Jean Fraser - Fwd: Planning Board Meeting on 133 York St is scheduled for TONIGHT at 5:30 PM

Subject: Planning Board Meeting on 133 York St is scheduled for TONIGHT at 5:30 PM

for P.S.
The Planning Board Meeting on 133 York St is scheduled for **TONIGHT at 5:30 PM in room 209 at City Hall**. Below is a summary of the two recent meetings along with concerns raised by abutters. If you share any of these concerns, please try to attend tonight's meeting.

August 30th: 133 York Street (Public Information Meeting)

EROSION CONTROL AND LANDSCAPE PLAN

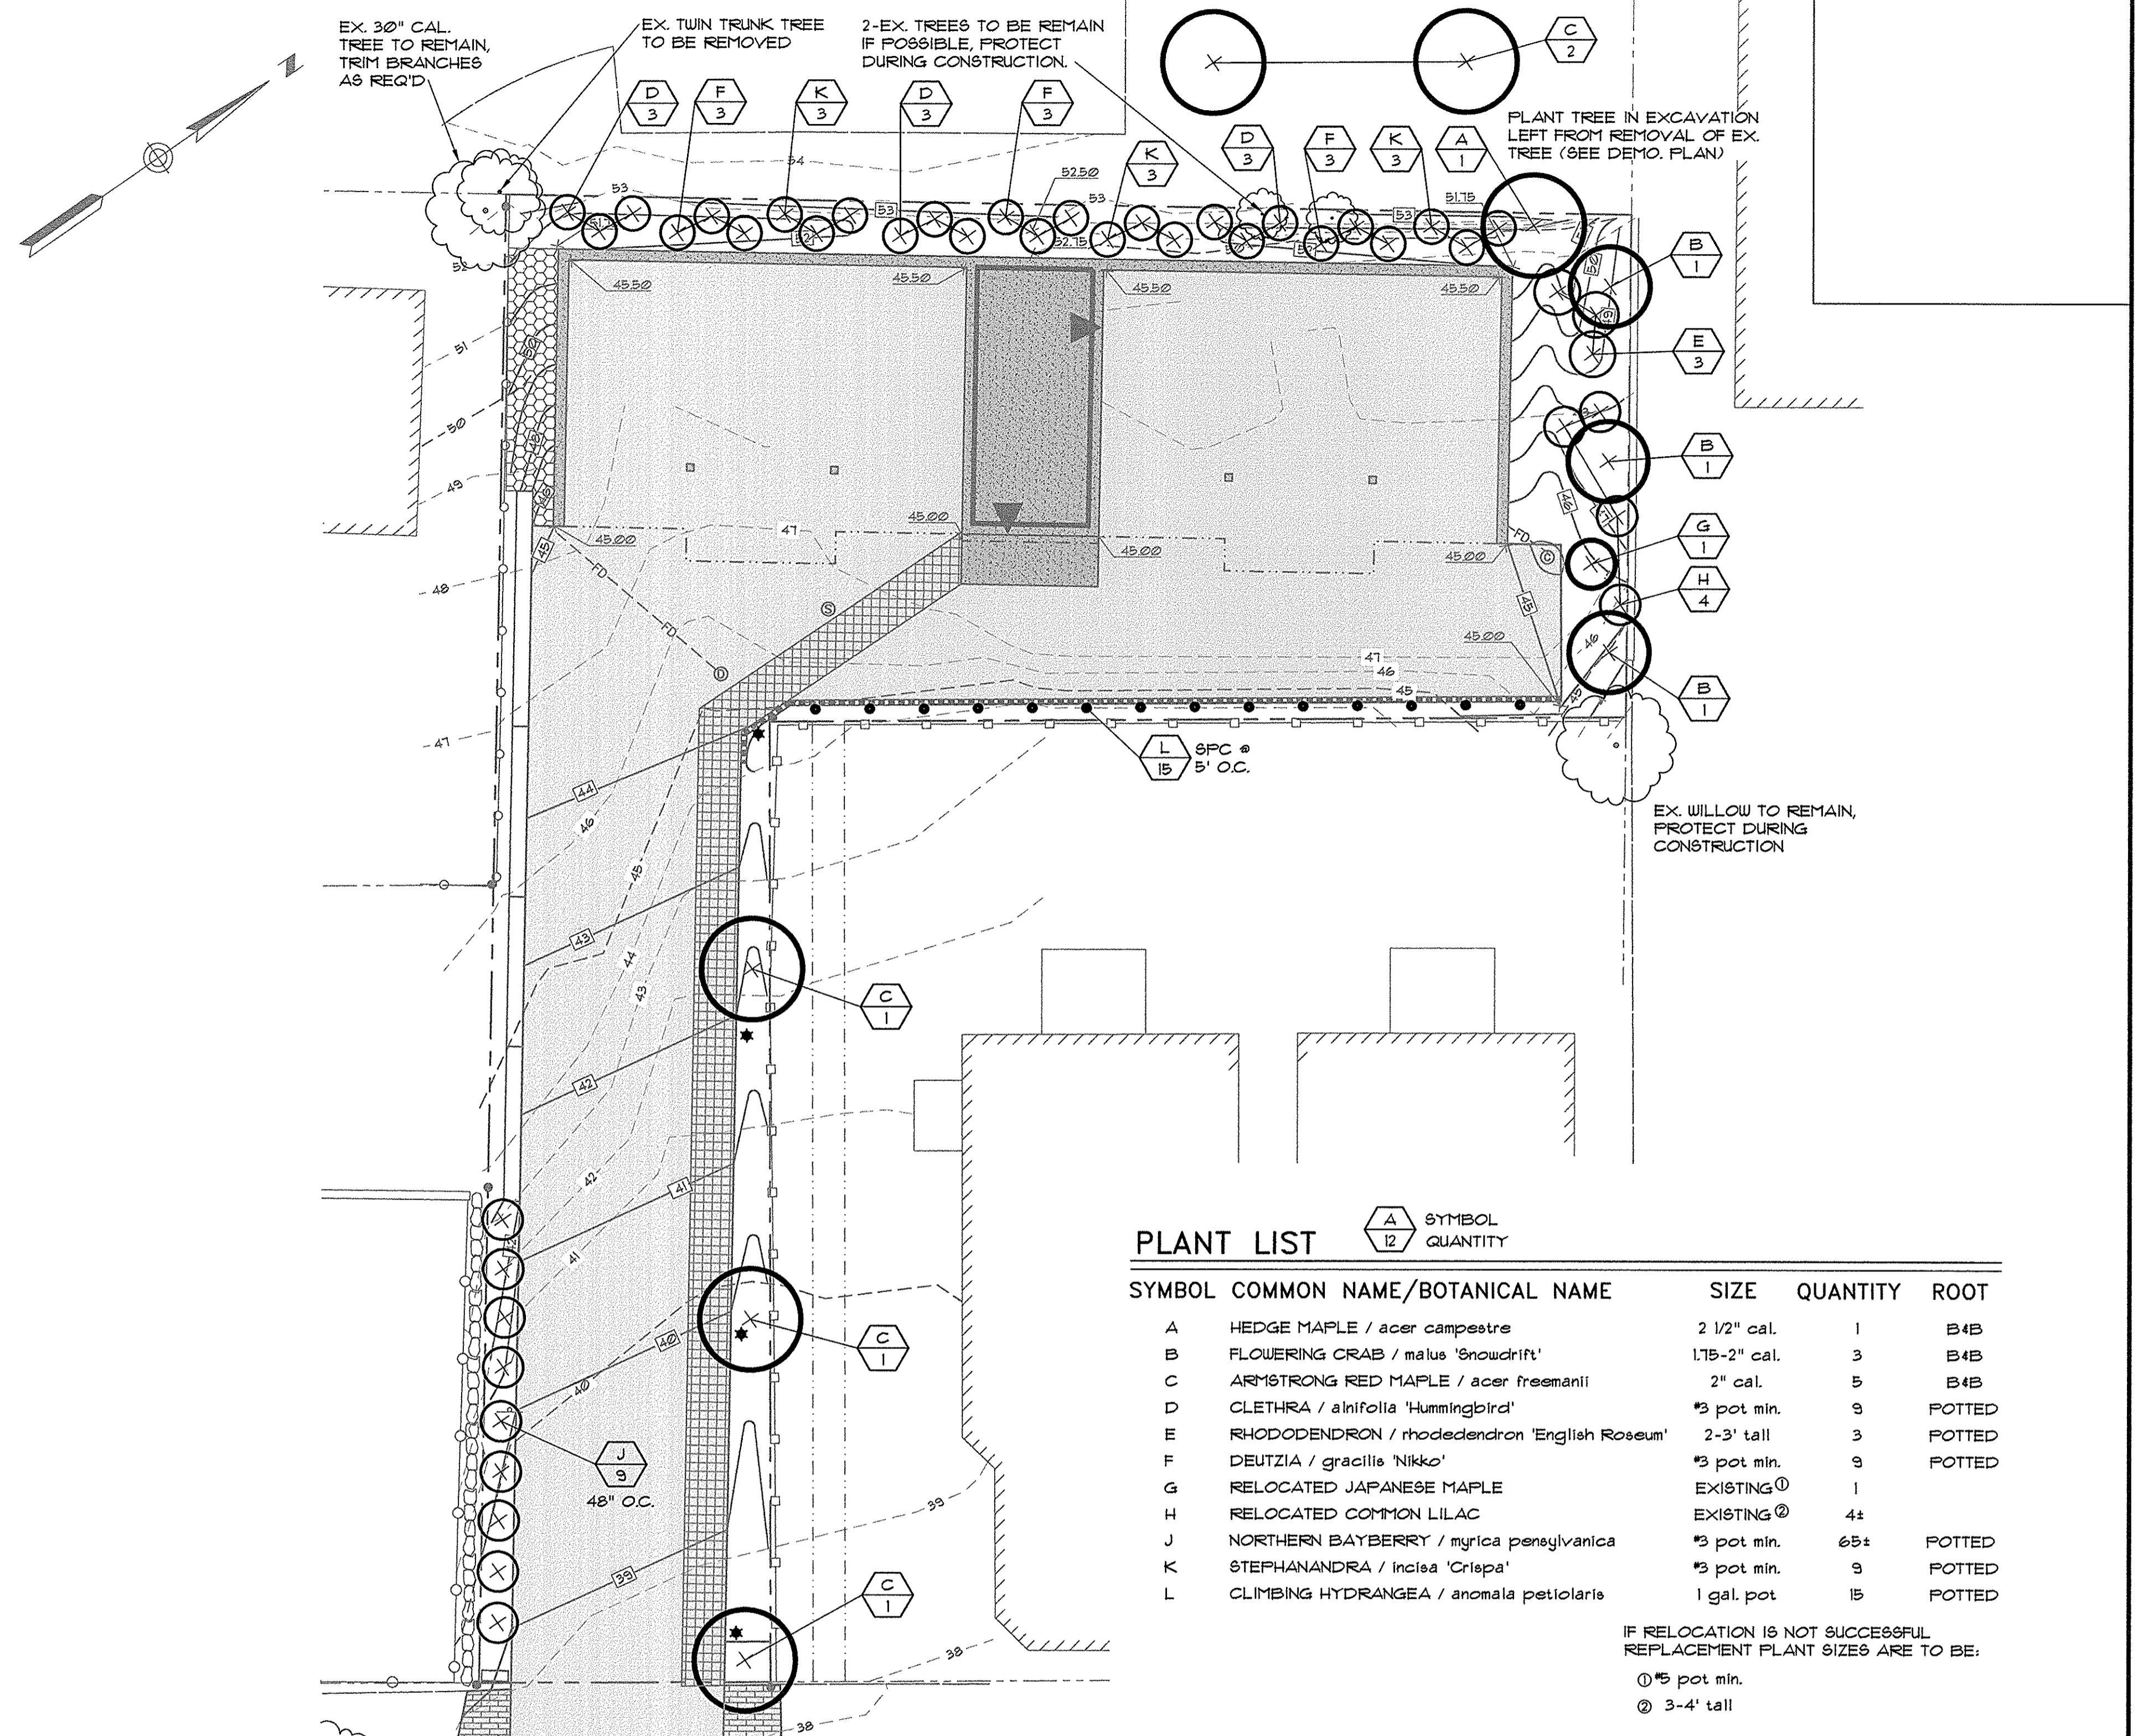
Jeff Tarling did not raise concerns about the removal of the large tree near the Townhome property line. Note: the tree appears to be sitting on the property line between 133 York and McCormick Place (behind 133 York).

Jeff did raise the concern about the lack of privacy / screening in the design and may recommend a green wall between 133 York and the rear of the Flats.

1. Concerns raised in the first meeting regarding privacy, screening, and the maintenance of the large tree near the Townhome property line were not considered by developers
2. The developers stated that there are no provisions being made to maintain screening or privacy for the rear residents of the Flats

3. Headlights from underground parking area will shine directly into the windows of the rear Flats first floor residences
4. The water abatement plan is of serious concern given the present volume of runoff into the Flats basement
5. Storm water in the last 6 months alone have caused flash flooding on York Street at the base of the 133 York driveway and a manhole cover near the York / High intersection to burst open.
6. Questions were raised regarding access to the construction site. Who will be granting this access?
7. Abutters in Townhomes have not been notified of public meetings; they have learned of the meetings from the Flats residents.
8. This public meeting was scheduled on a Friday night before Labor Day weekend which negatively impacted public input and turnout.
